## Application by Associated British Ports for the Immingham Green Energy Terminal

### The Examining Authority's **DRAFT** first written questions and requests for information

Issued on Friday 12 January 2024

Figure 2.3

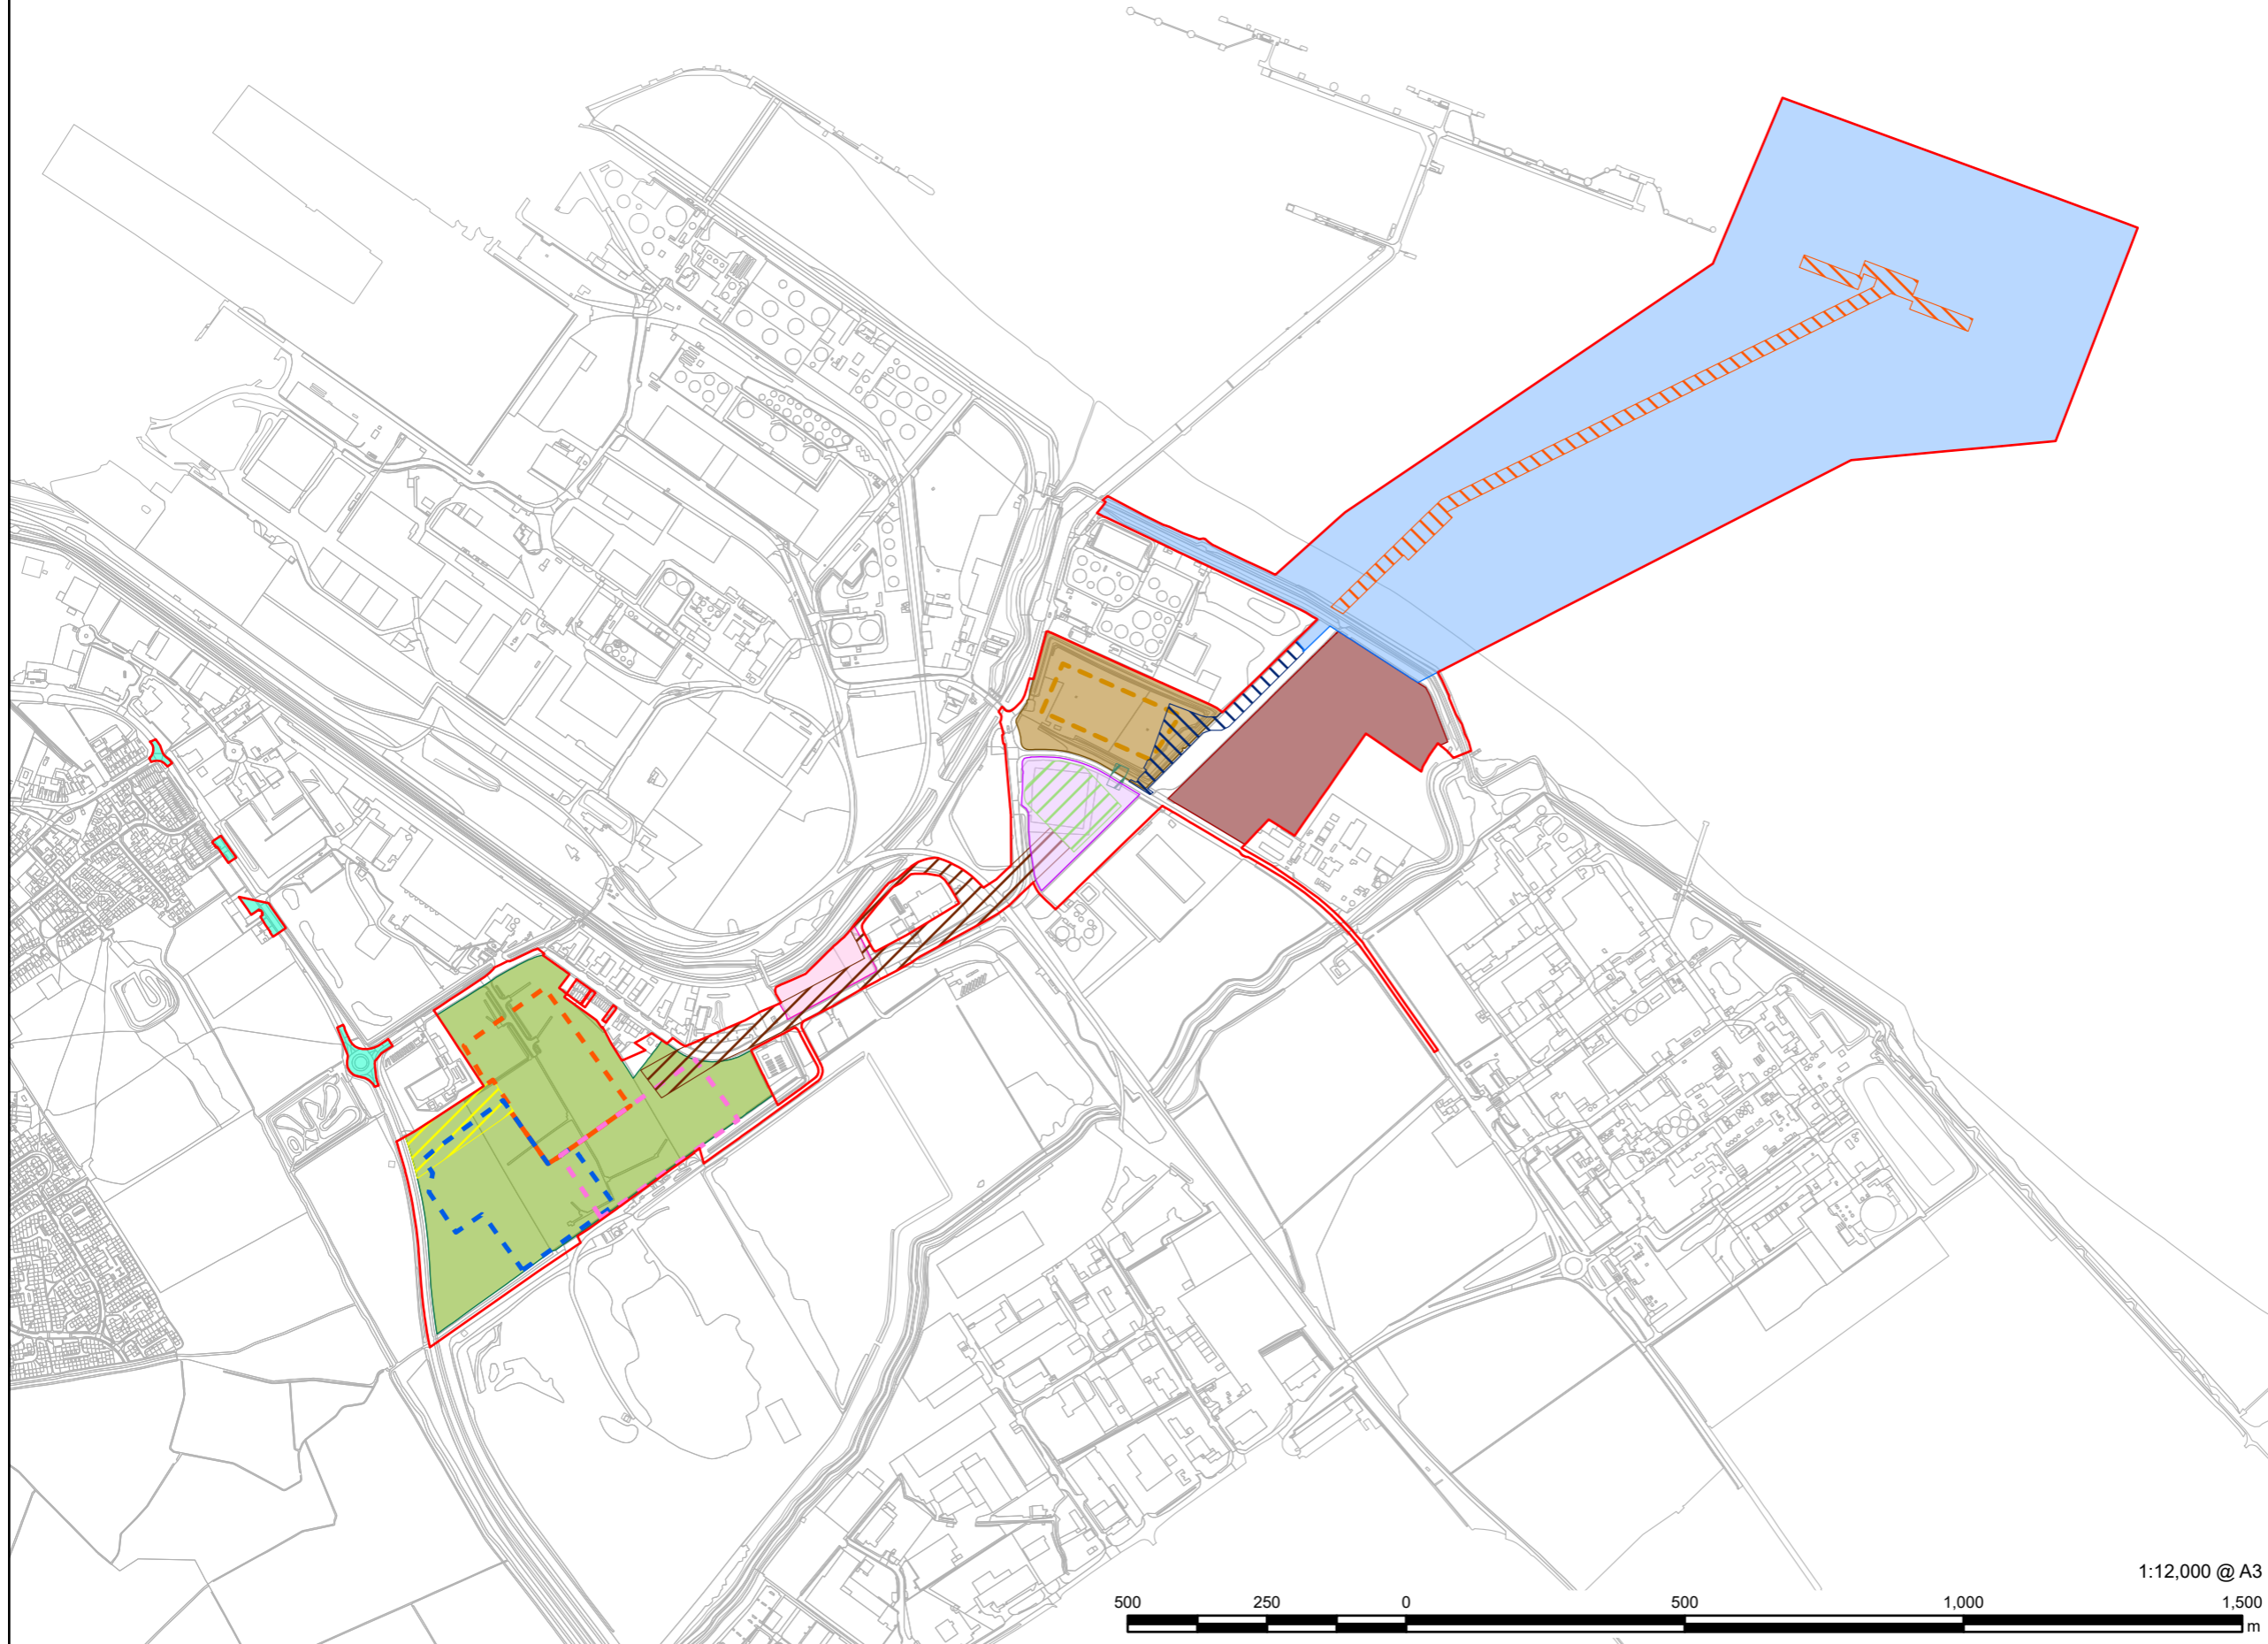
Q1.4.2.3	Applicant	<p><b>Access from Laporte Road</b></p> <p>Provide contextual elevations of the proposed road accesses from Laporte Road into Work Nos. 2 and 3.</p>
Q1.4.2.4	Applicant	<p><b>Temporary Construction</b></p> <p>Work Nos. 8 and 9 are identified as Temporary Construction areas [APP-044].</p> <p>a) Provide indicative plans showing the extent (area and maximum heights) of the temporary constructions in Works 8 and 9.</p> <p>b) Provide indicative temporal requirements for these elements and whether they relate to specific Work Nos.</p>
Q1.4.2.5	Applicant	<p><b>Work No. 7</b></p>
